**KIRKLEES METROPOLITAN COUNCIL
INVESTMENT & REGENERATION SERVICE**

**DELEGATED DECISION TO DETERMINE APPLICATIONS FOR
CONSENT, AGREEMENT OR APPROVAL REQUIRED BY CONDITION**

Reference No:	2023/44/90915/E
Site Address:	adj, 115, Westfield Lane, Wyke, BD12 9LY
Description:	Discharge of conditions 6, 7, 8, 9, 10, 11, 12, 13, 14, 15, 16, 18, 19, 20, 21, 22, 23, 25, 27, 28, 30, 31, 32, 33, 34 and 36 of previous permission 2023/91472 for the variation of conditions 9, 11, 12, 22, 23, 25, 27, 29, 30, 33, 34 and 38 of previous outline permission 2020/90436 for the demolition of one dwelling and erection of residential development and associated works with details for access
Recommending Officer:	Callum Harrison

DECISION – Discharge of Conditions – Split Decision

Westfield Lane, Wyke
SITE PLAN AND LOCATION PLAN

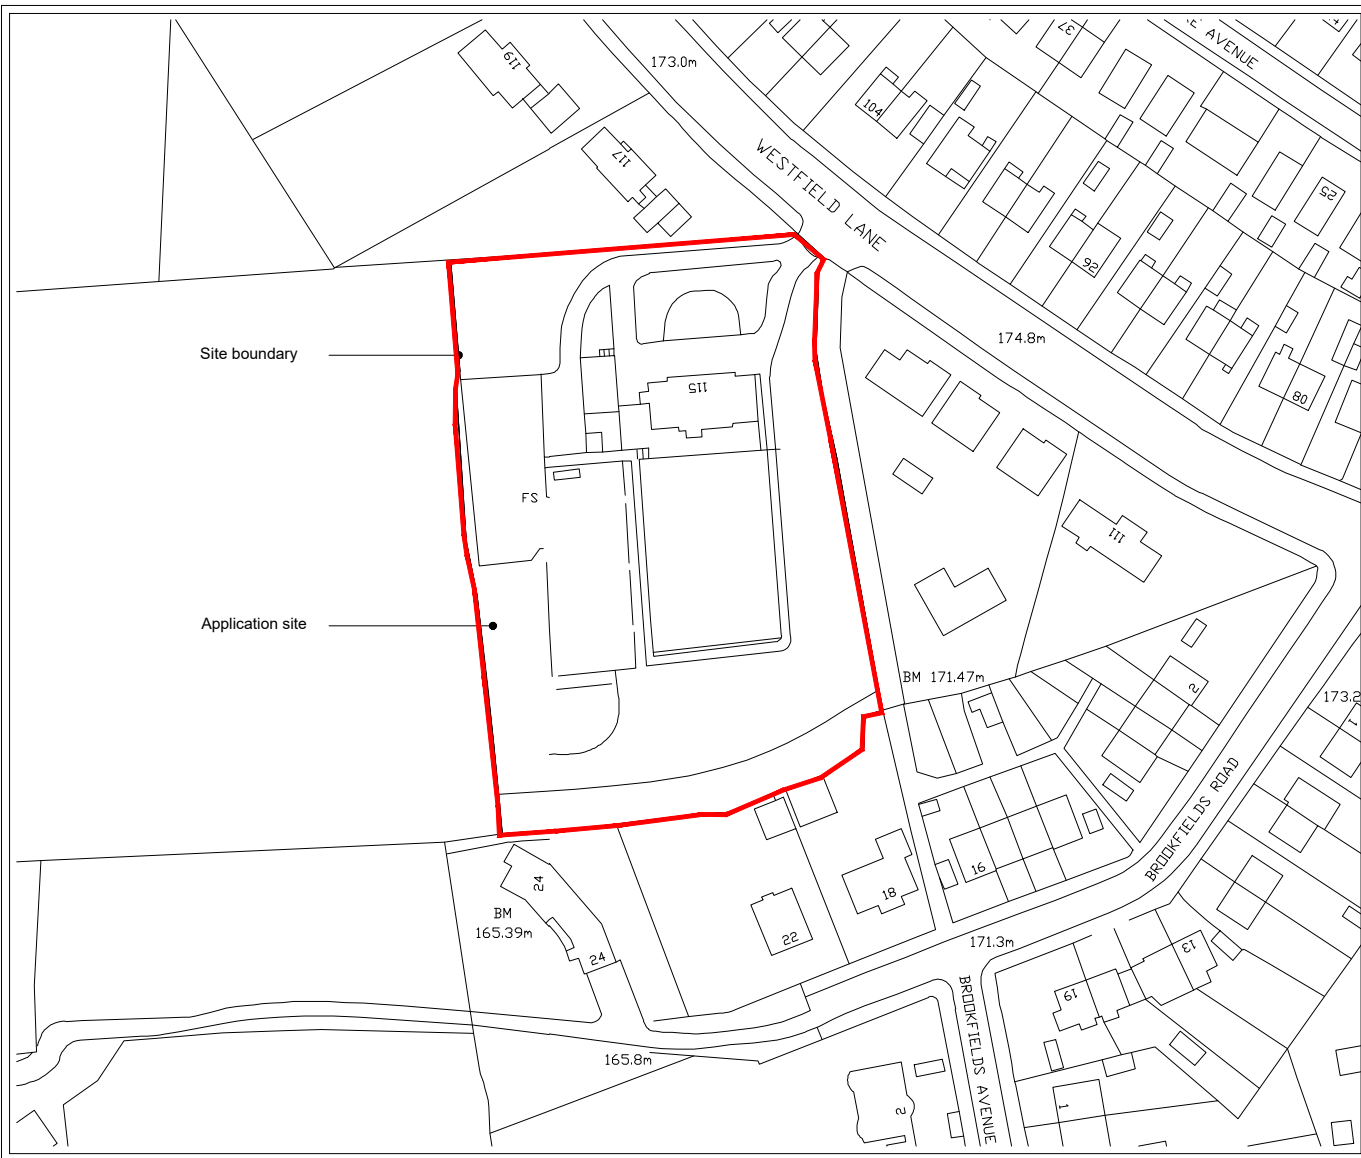
KC Waste Strategy were consulted on the reserved matters application. In order to discharge condition 22, the submitted details need to be agreed in writing by the LPA on the reserved matters application. As the reserved matters application is still pending decision, **condition 22 cannot be discharged at this time.**
